October 16, 2024

Brady Shyrock, on Behalf of Galloway
1155 Kelly Johnson Blvd., Suite 305
Colorado Springs, CO 80920

RE: Constitution Storage Development; Full Spectrum Detention Pond Certification

DETENTION POND - GRADING EXHIBIT

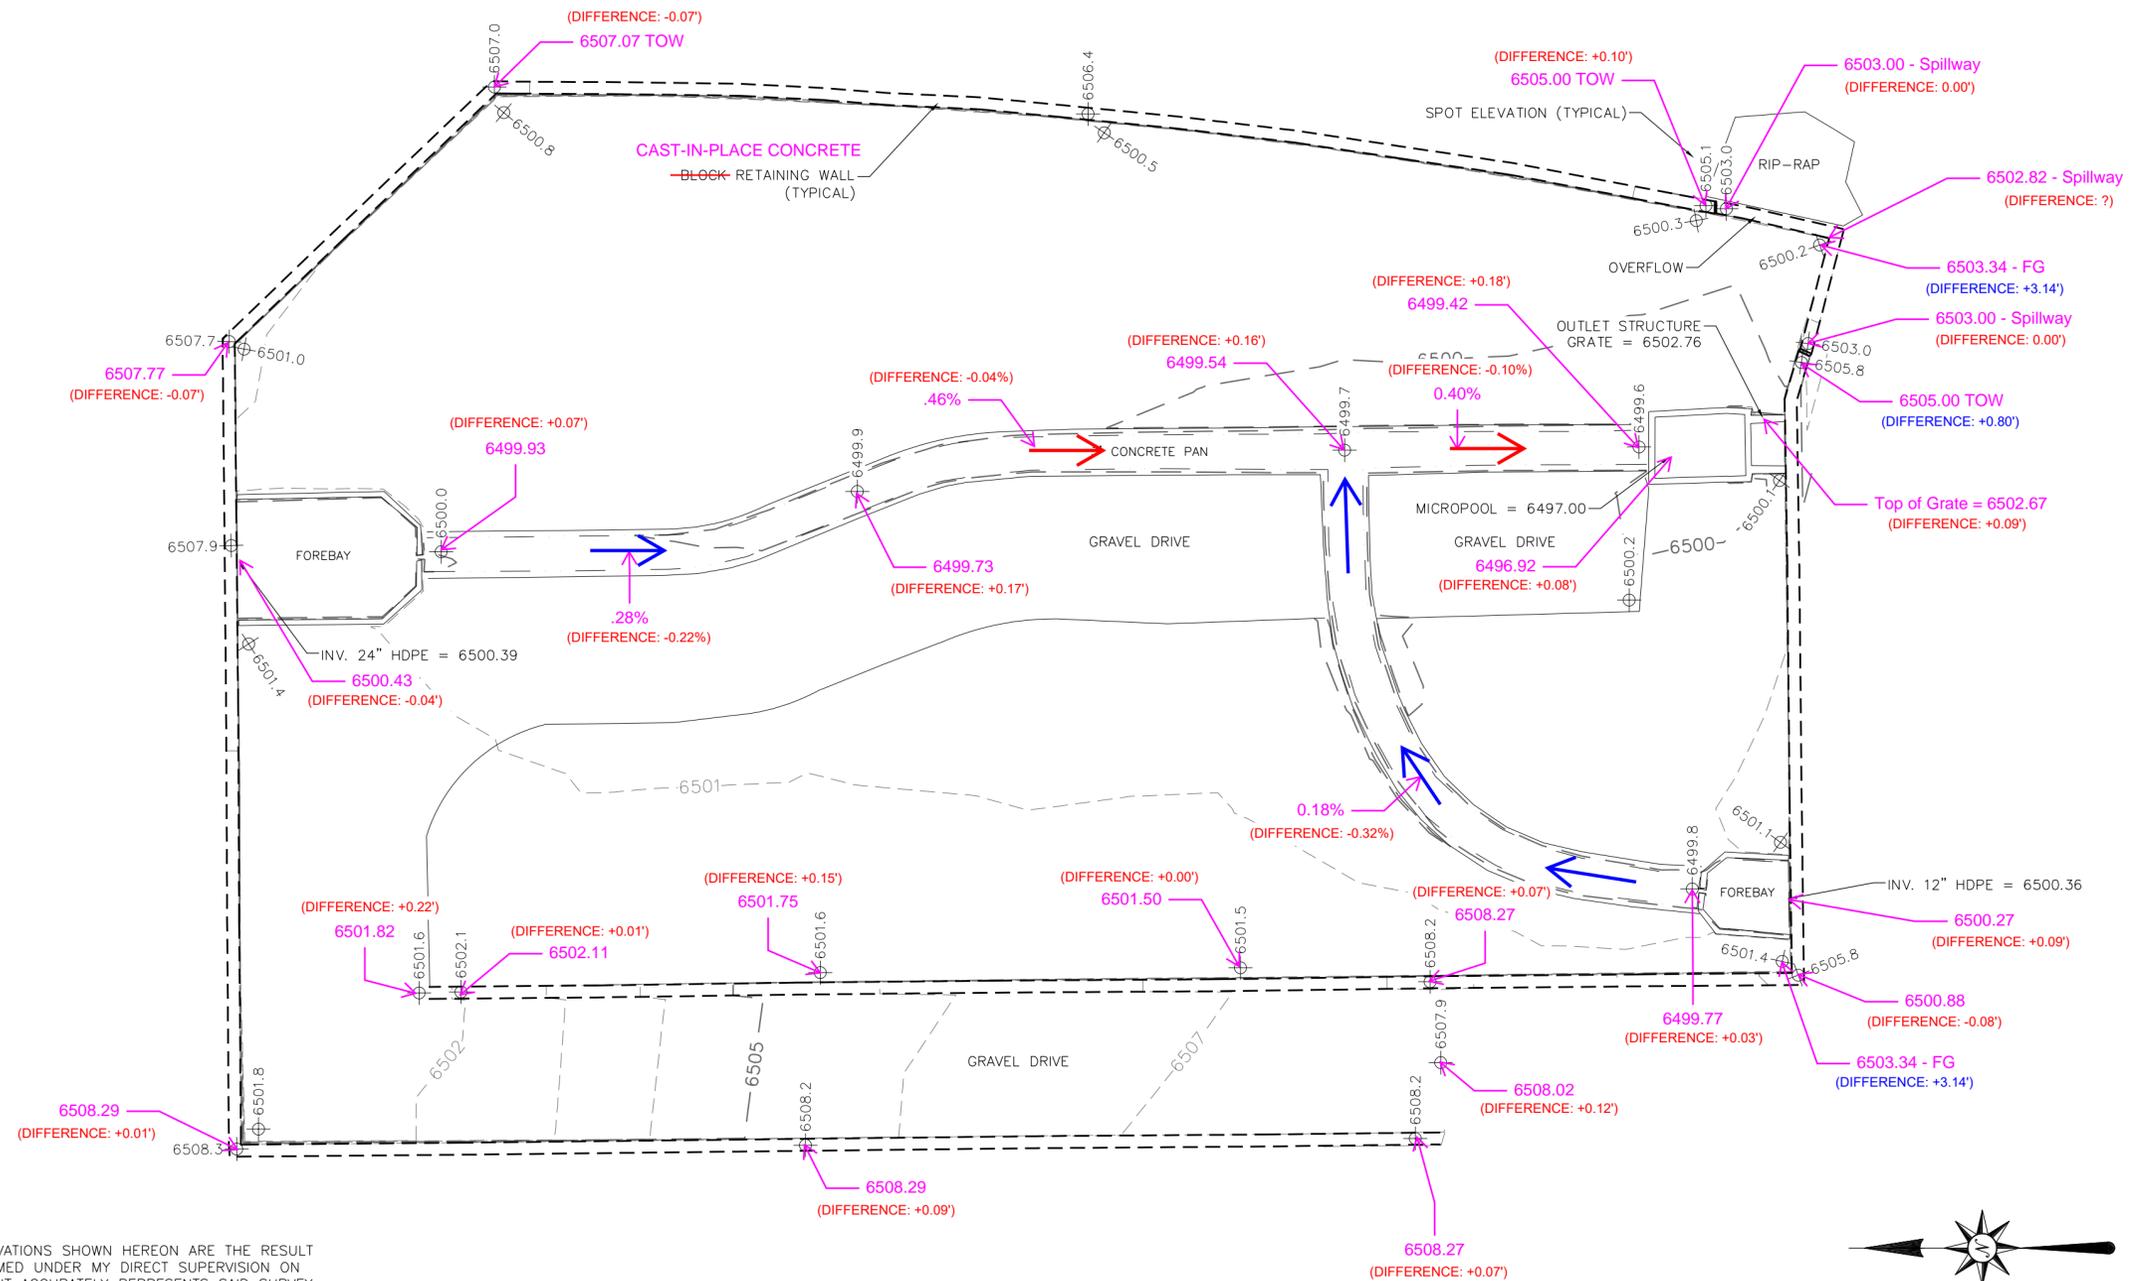
One item to note as an exclusion to this overall pond certification, there are two portions of the concrete trickle channel that were constructed below the minimum slope of 0.40% per the County DCM as reflected on the R & R Engineers-Surveyors, Inc. as-built survey (attached) shown in blue arrows. These two areas still have positive drainage and could be attributed to construction tolerances.

1 POND OUTLET STRUCTURE
 SCALE: 1" = 2'

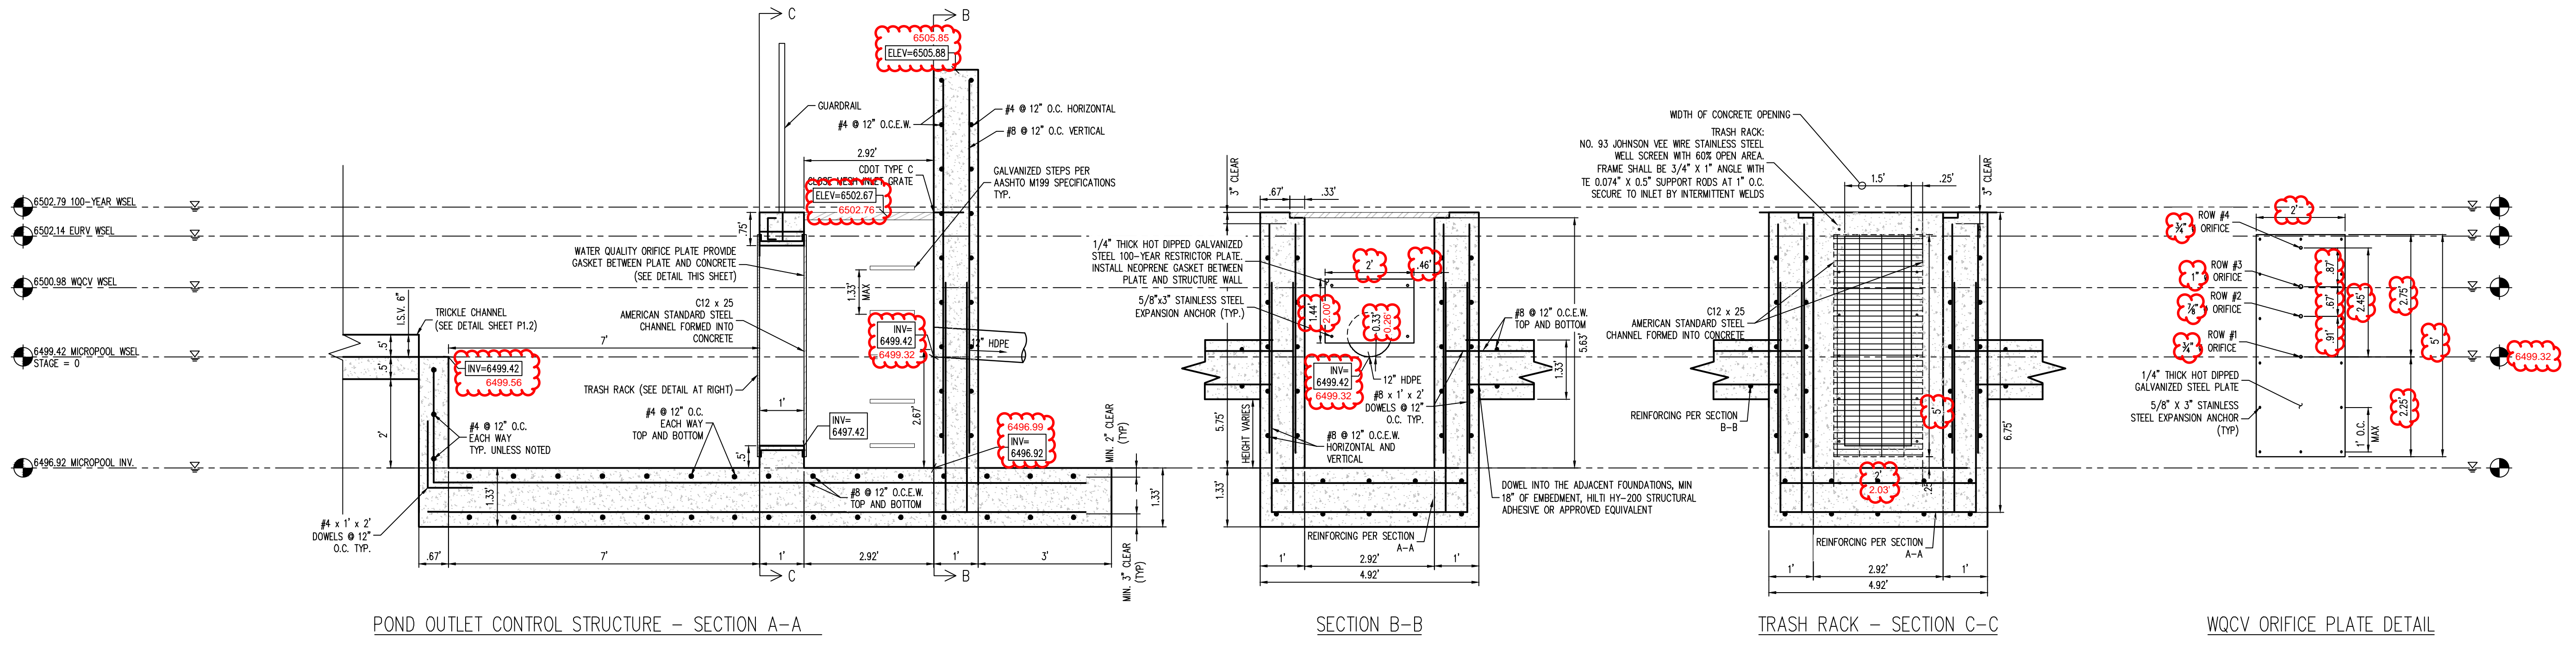
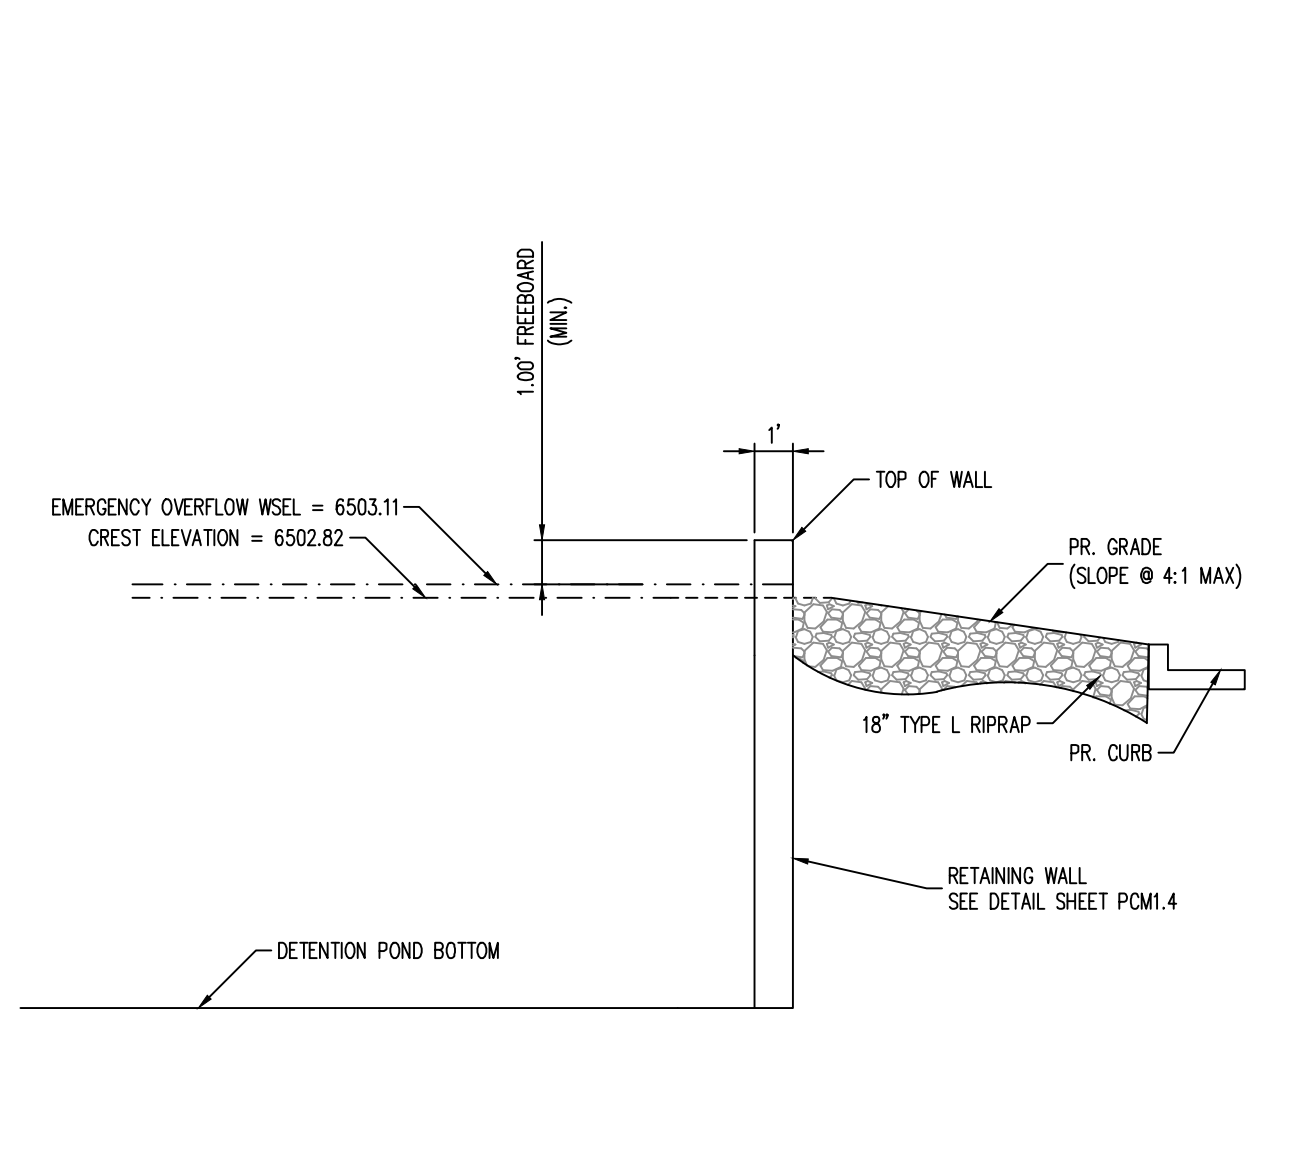
PPR2343 called for an 8" pipe.
Please confirm **APPROVED PLANS SHOW 12" HDPE PIPE**
